UNSW Cliffbrook Campus

JHA's Response to Acoustic Review

Title	JHA's Response to Acoustic Review
Project	UNSW Cliffbrook Campus Redevelopment
Description	Response to DA review
Key Contact	RO

The following addresses the review prepared by Andrew Beatty of Beatty Legal letter dated 31 July 2017 on behalf of nearby residents of UNSW Cliffbrook Campus Proposal, and a review of JHA's Acoustic report for Development Application by Brian Clarke of Wilkinson Murray included with the letter.

Wednesday 27 April 2016

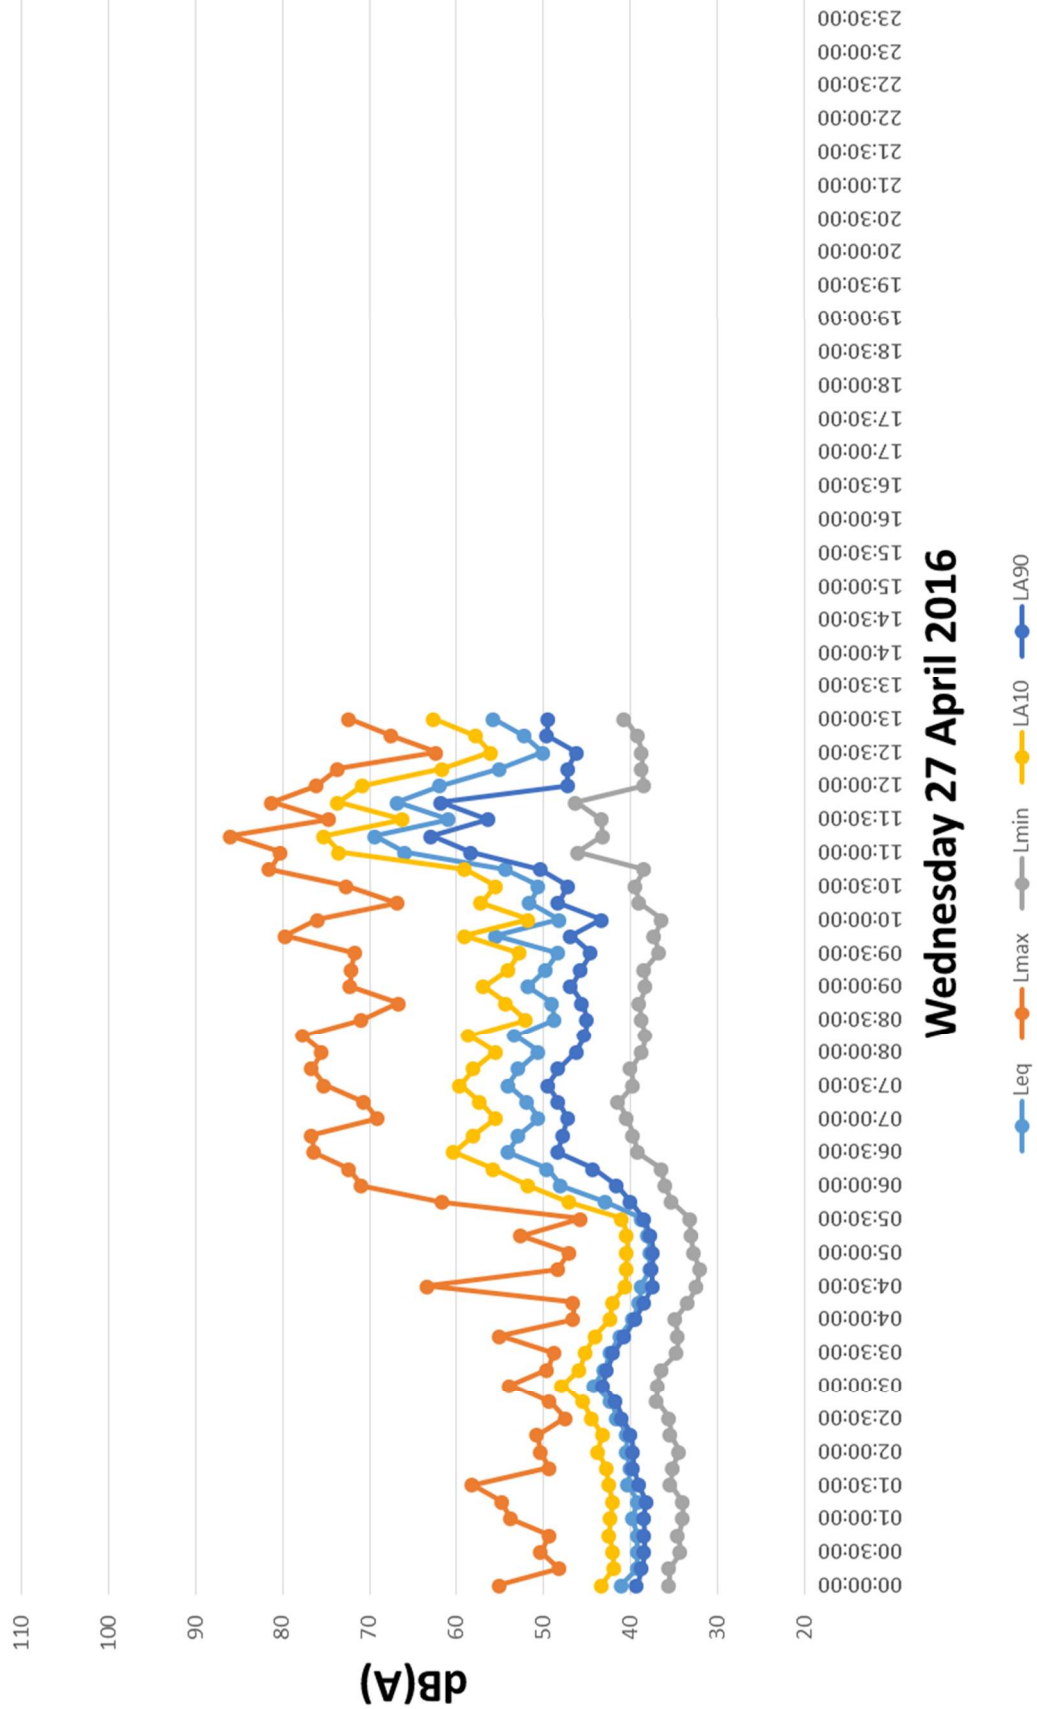
Unfortunately, the results of noise logging appear to be contaminated in that noise levels measured by the logger are much higher than those measured by JHA in the surrounding streets or by myself when on site. For example, street attended background noise measurements in the day were reported to be 42 dBA whilst noise data from the loggers for the day is reported to be 53dBA, this is a significant difference. In addition, my measurements in the afternoon were in the order of 38 dBA compared to the reported logger noise levels.

Furthermore, the fact that night L_{Aeq} and L_{A90} noise levels are reported at the same level further indicates that the noise logger data is unreliable and not suitable for the establishment of site specific noise criteria. Therefore, it can be concluded that correct site-specific noise criteria, both for construction and operation, has not been established therefore no correct assessment can be conducted on the development. As such the potential impacts or appropriate mitigation measures cannot be established.

Wilkinson Murray was comparing the measurements made at Battery Street (where the University does not share a boundary with No.12 Battery St) with the “ocean-front” side where the university does share a boundary with No.12. The logger measurements reflect the continuous noise from the ocean, not from ‘contaminated noise results’. Refer to the circled logger location and plan above taken from the JHA report dated 8 May 2017. Additional logger measurements were made to show that the measurements are not ‘contaminated’ as asserted by Wilkinson Murray. These additional results are included at the end of this report in Section 2.

The logger L_{Aeq} and L_{A90} noise level measurements from the JHA report dated 8 May 2017 reflect the continuous noise from the ocean, not from contaminated noise results. Hence the closeness of the L_{Aeq} and L_{A90} noise levels, not from contaminated noise results.

The location of the logger, near the ocean, resulted in similar results for L_{Aeq} and L_{A90} . This is because the ocean is a relatively constant source of noise, so the documented L_{A90} (lowest 90% of levels in the measurement period) result is similar to the overall L_{Aeq} . The additional noise measurements, located further from the ocean, document similar L_{Aeq} (overall noise) and a greater difference in L_{Aeq} and L_{A90} , which is to be
